DRB Application No.: 03-01154 (P&F)  
Project Name: **LANDS OF JOE MOYA**  
Agent: Surveys Southwest Ltd.

Project # **1002811**  
EPC Application No.  
Phone No.: 998-0303

18. **Project # 1002811**  
03DRB-01154 Minor-Prelim&Final Plat  
Approval

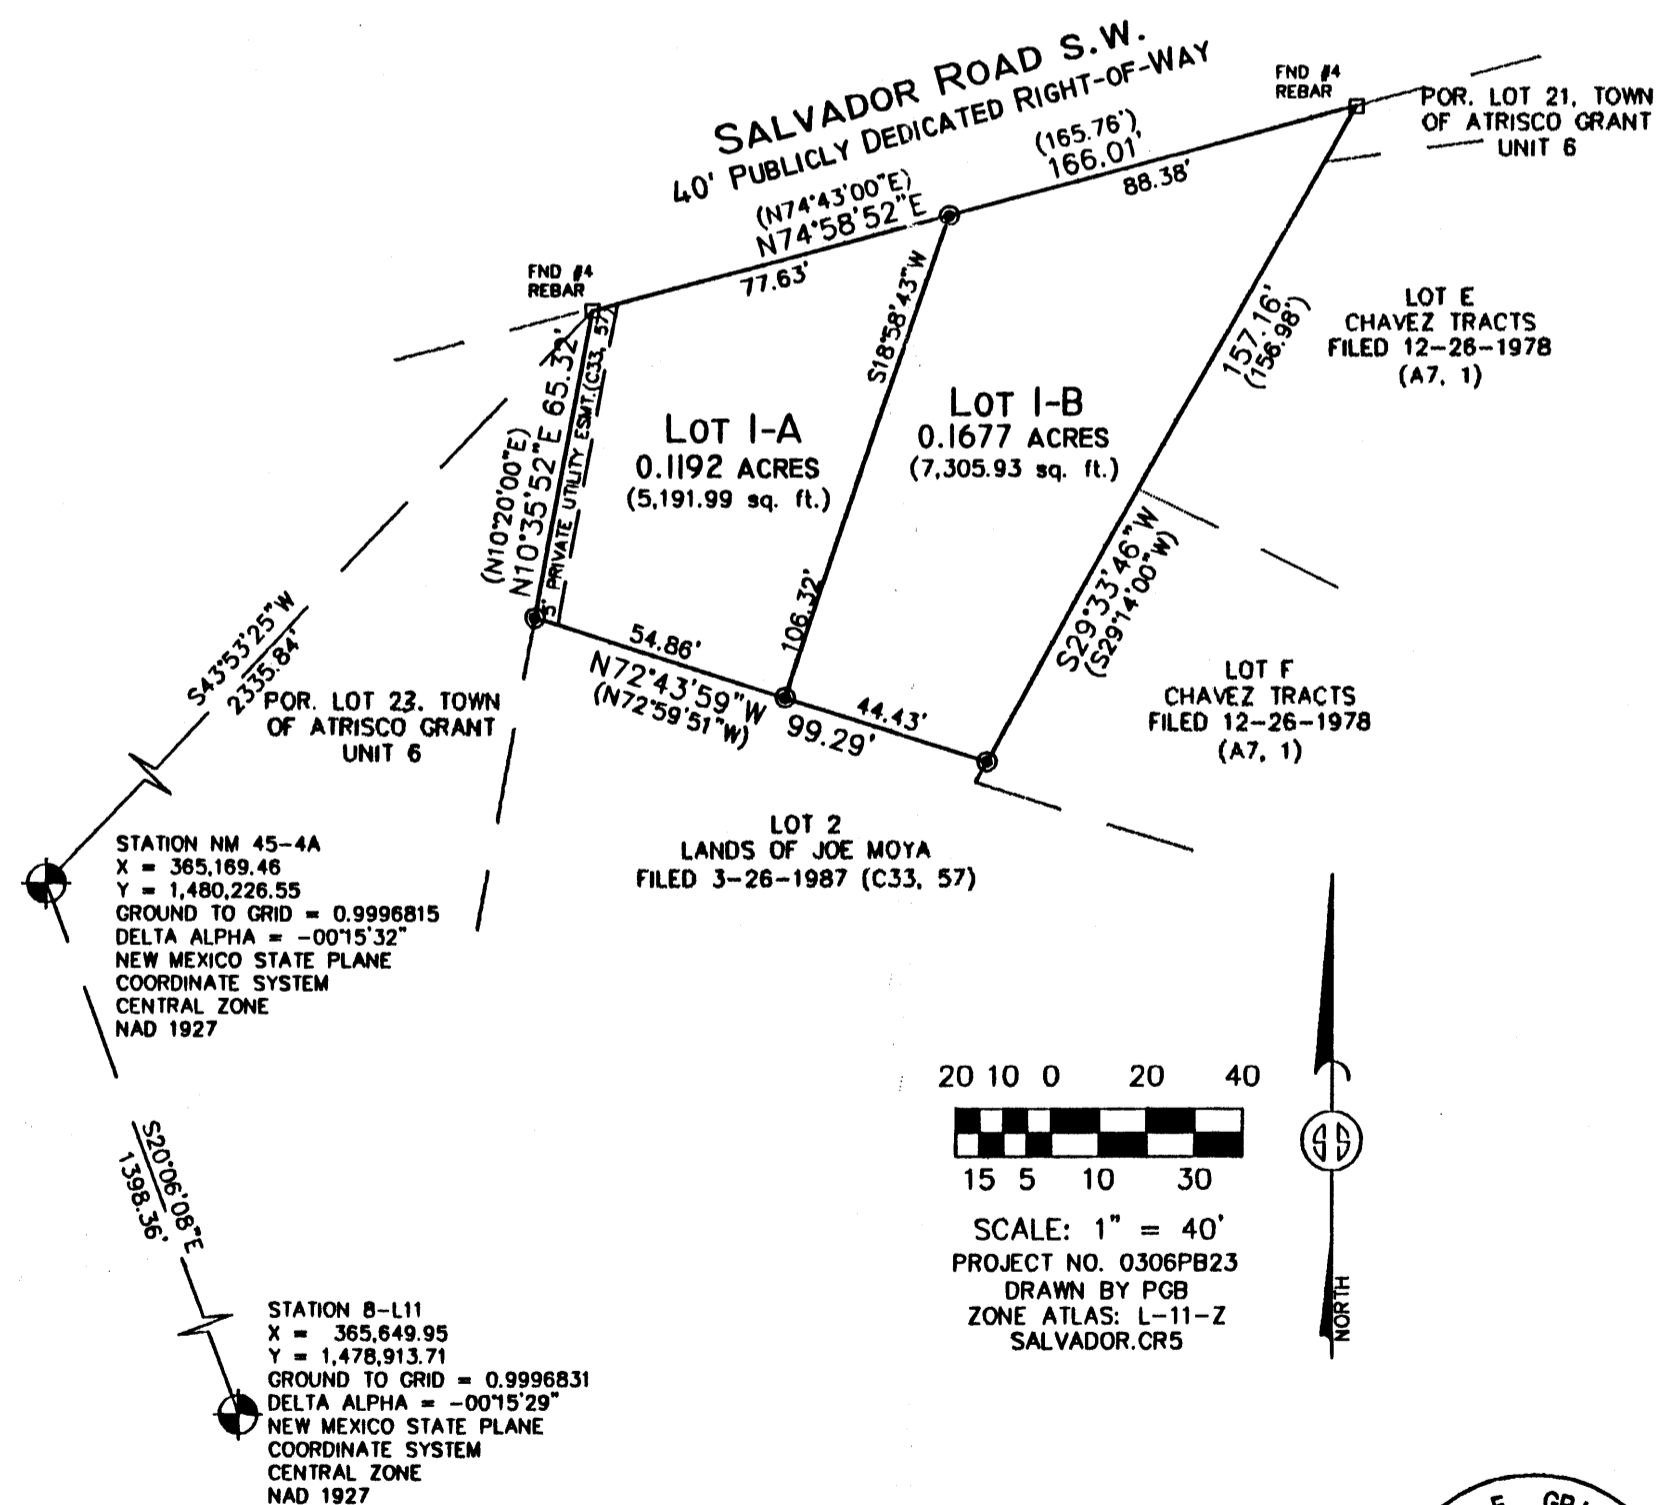
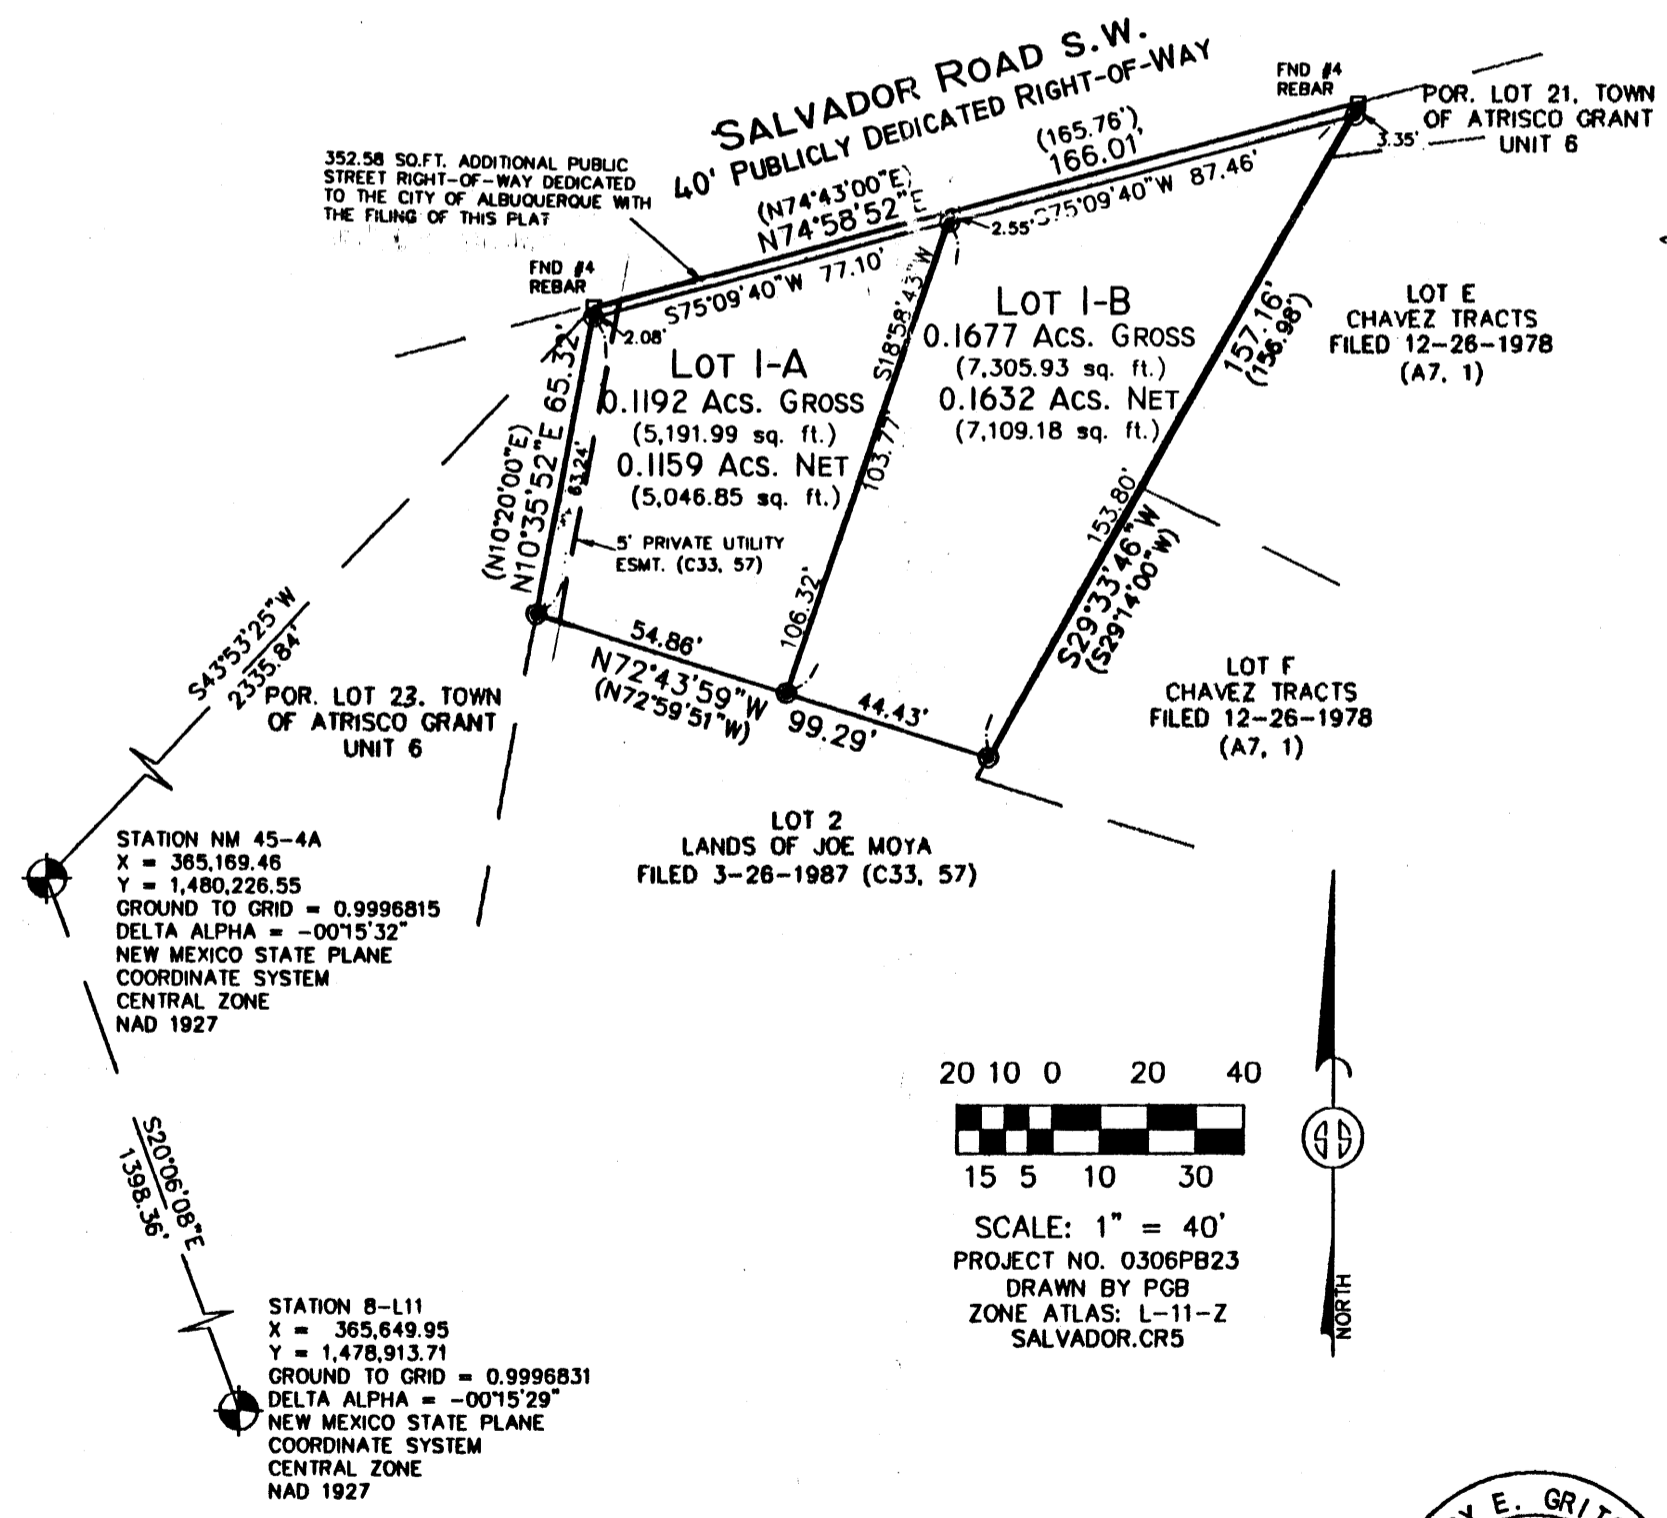
TRANSPORTATION: Dedicate R/W to Face of wall.

No.	Comment
<input type="checkbox"/>	Right-of-way dedication on Sandoval road.
